**STATEMENT OF ENVIRONMENTAL EFFECTS: SECTION 75W APPLICATION TO MAJOR
PROJECT MP NO.08_0257 STAGE 1 (BUILDINGS 4 & 5) – 61 MOBBS LANE, EPPING**

Pursuant to Section 75W (1) (a) of the Environmental Planning and Assessment Act 1979, a 'modification of approval' is sought to vary Condition No. A2 pertaining to Major Project MP No. 08_0257 Stage 1 (Buildings 4 & 5) as approved on the 15 September 2010. The modification is to amend architectural plans to accommodate minor design changes to the approved architectural plans arising from design and construction compliance.

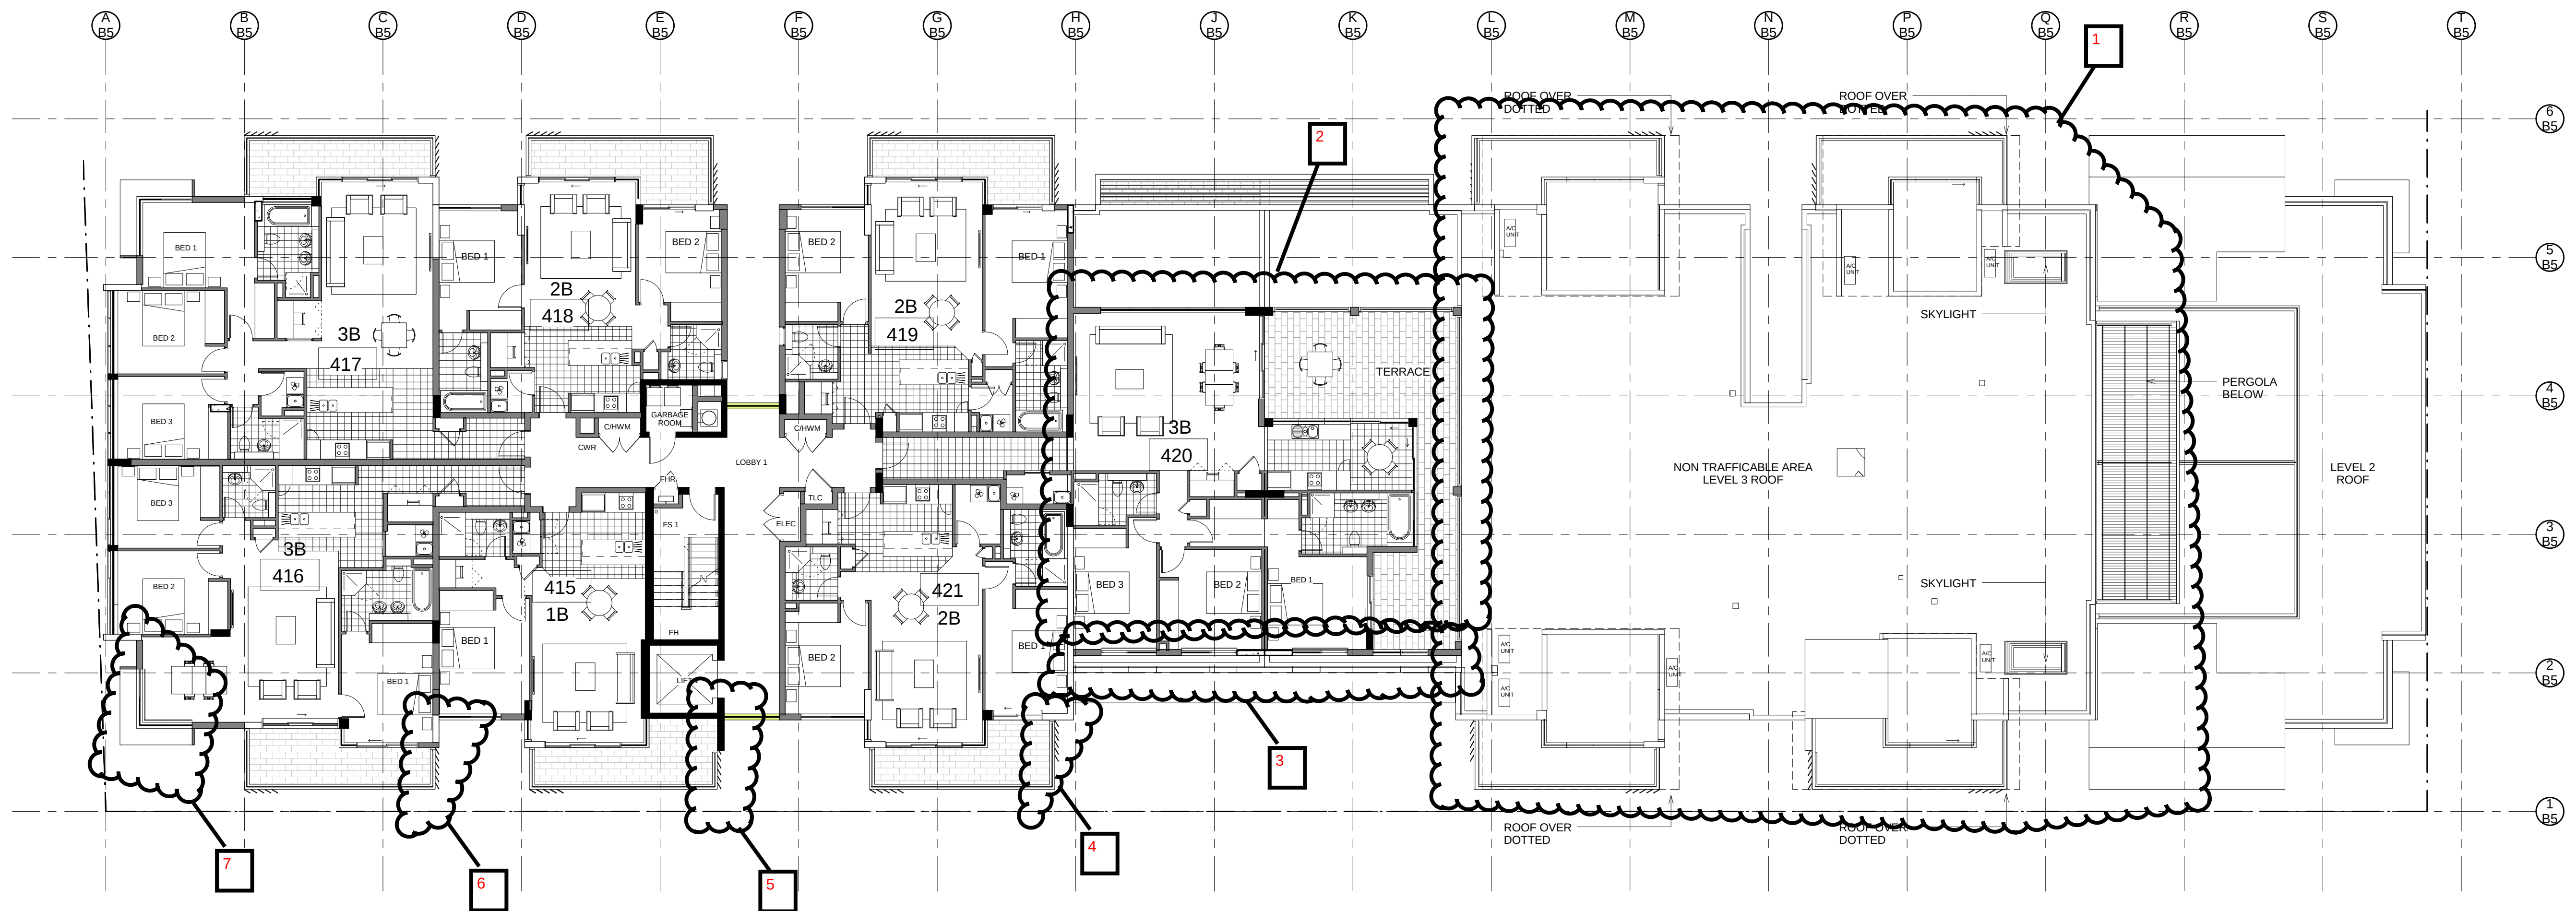
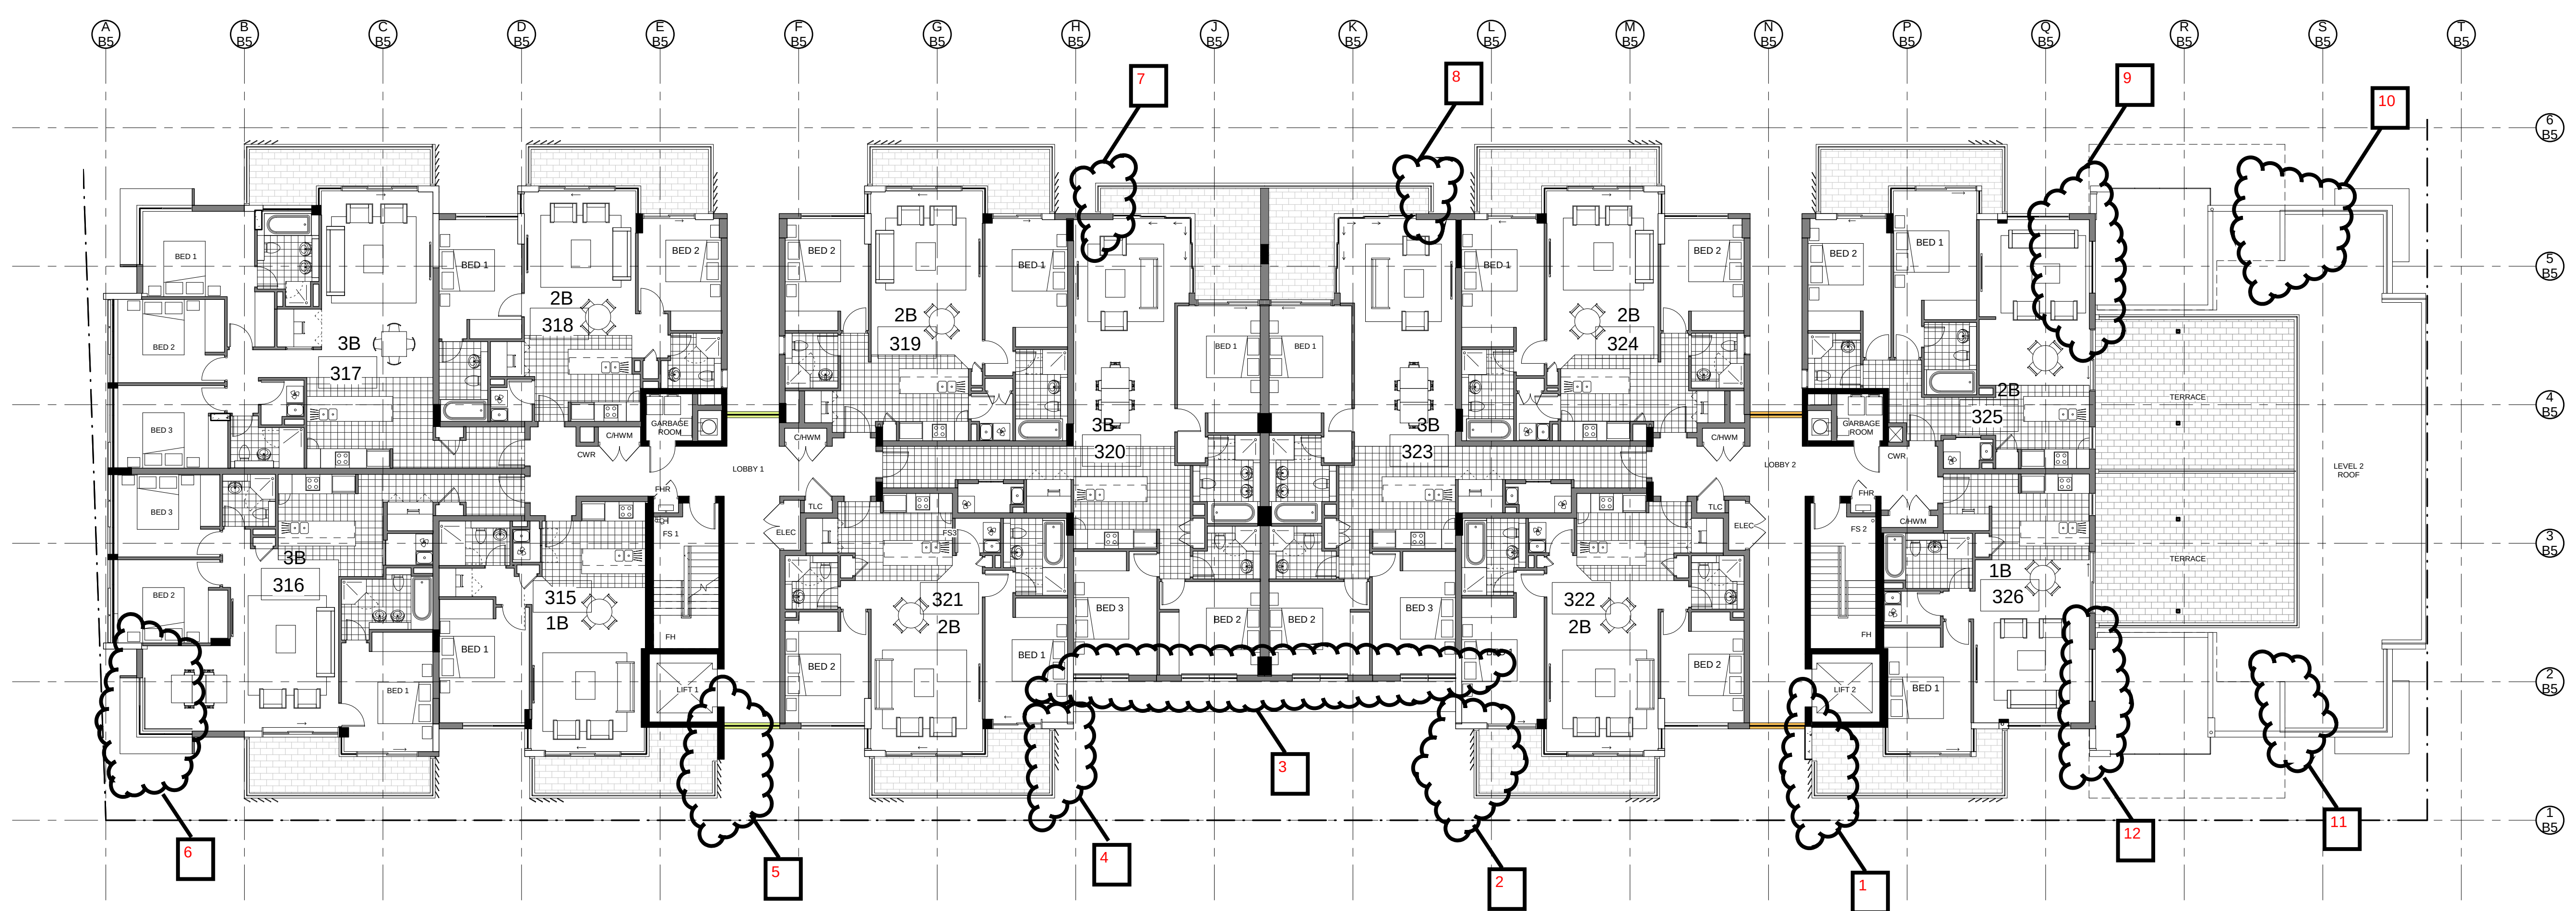
1. New louvre and concrete configuration
2. New louvre and concrete configuration
3. Amend precast panel and window configuration
4. New louvre and concrete configuration
5. New louvre and concrete configuration
6. Reduce size of window and awning
7. Delete louvre

8. Delete louvre
9. Precast panel and window reconfiguration
10. Parapet added
11. Parapet added
12. Precast panel and window reconfiguration

1. Roof configured
2. Unit area reconfigured and parapets amended
3. Precast panels and windows reconfigured
4. New louvre and concrete configuration
5. New louvre and concrete configuration
6. New louvre and concrete configuration
7. Reduce size of window and awning

Epping Park
61 Mobbs Lane, Epping
Stage 1 (Building 4+5)
REVISION
A5105
SECTION 75W ISSUE
B

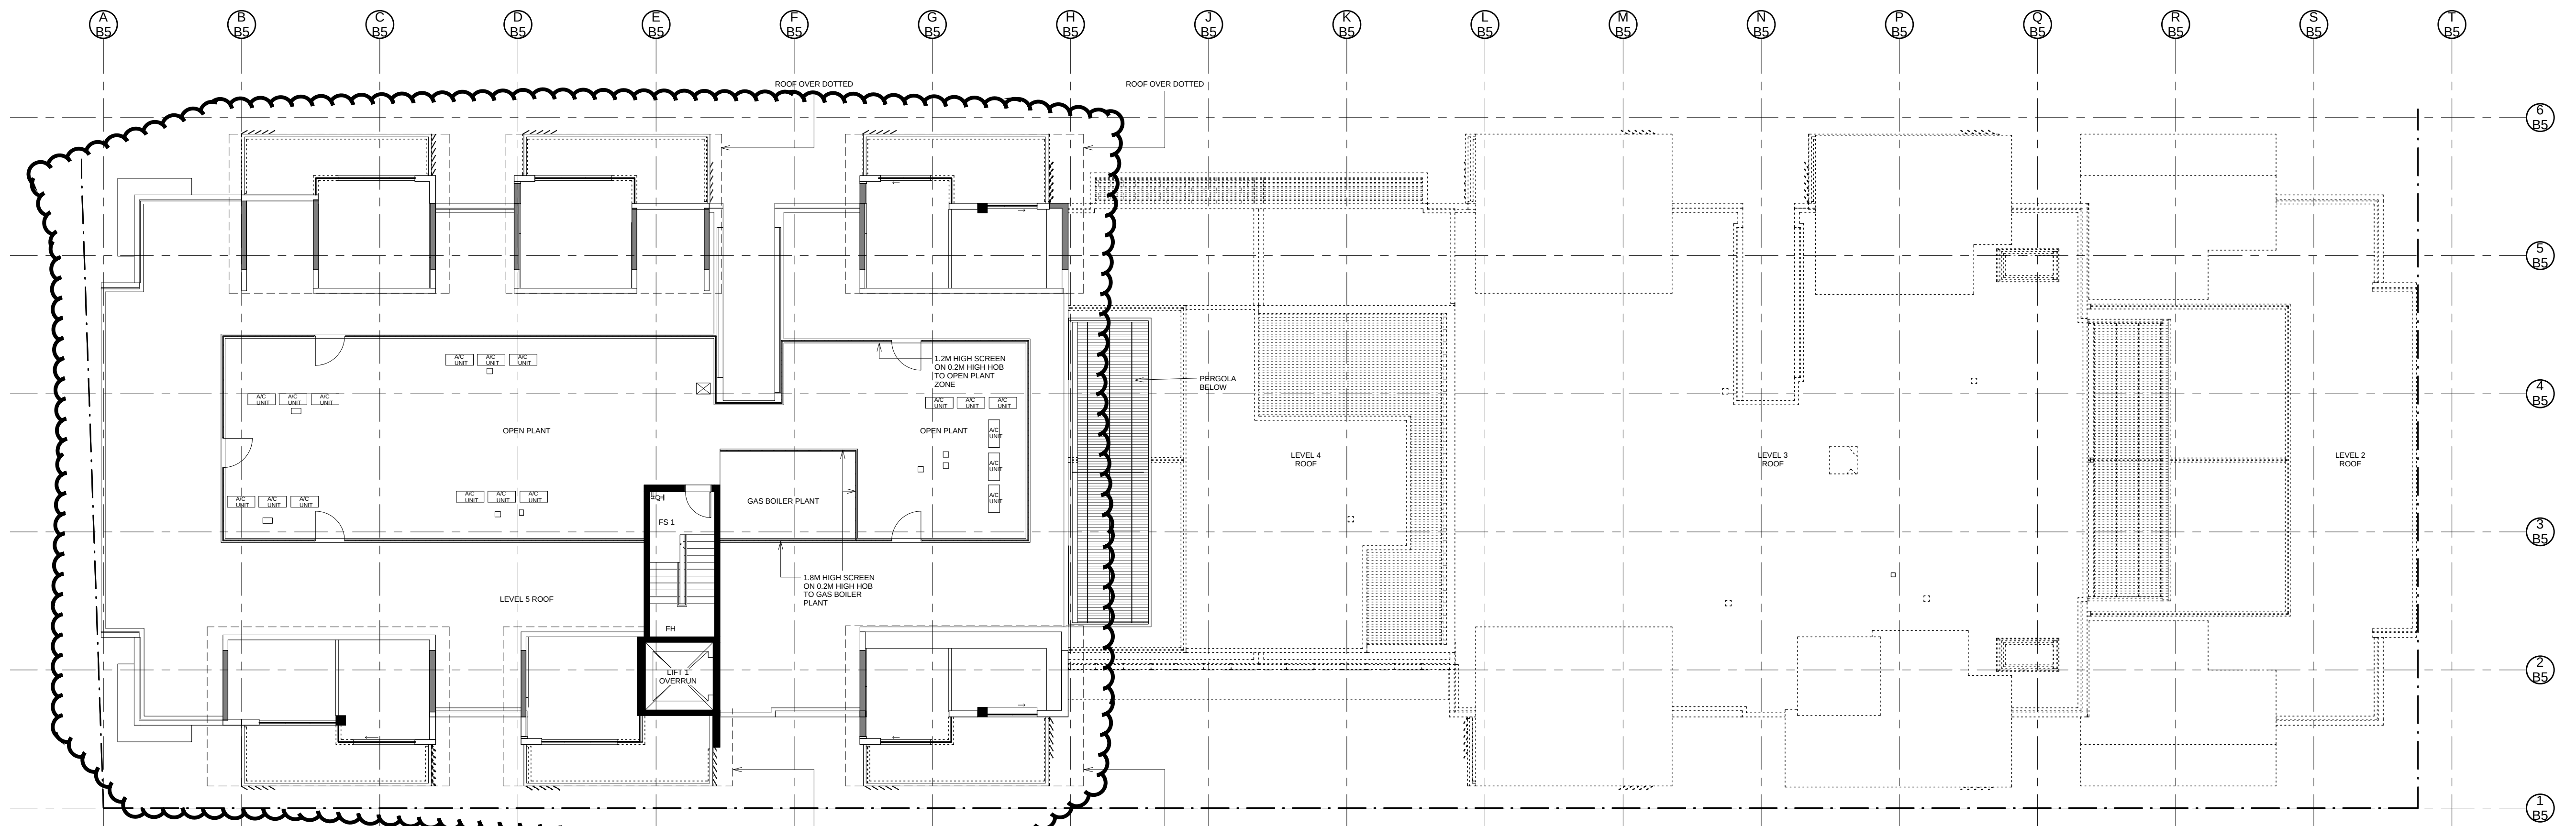
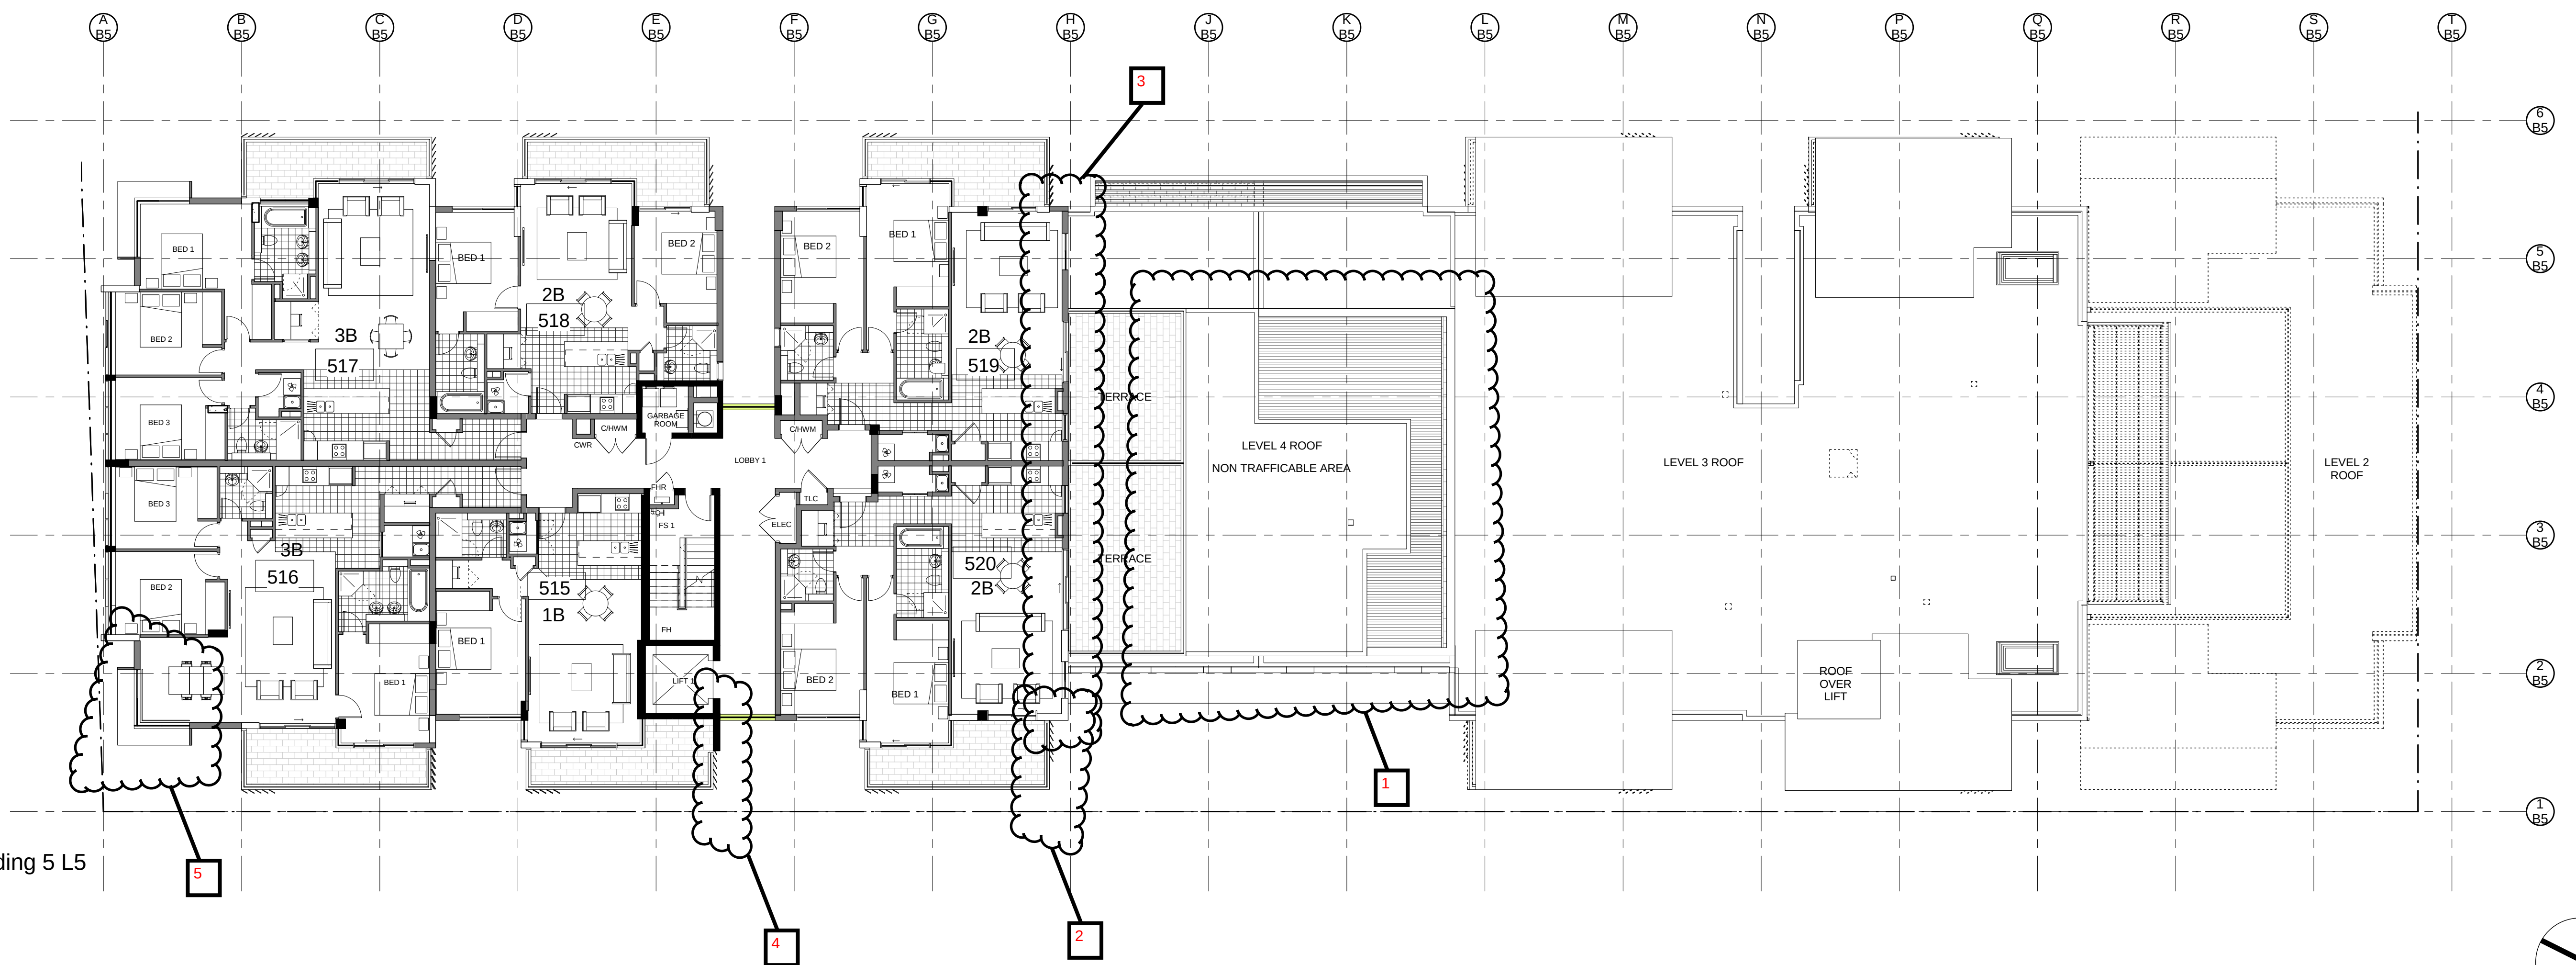
1. Roof area reconfigured
2. New louvre and concrete configuration
3. Precast panel and windows configured
4. New louvre and concrete configuration
5. Reduce size of window and awning

1. Roof area reconfigured

1. Roof area reconfigured
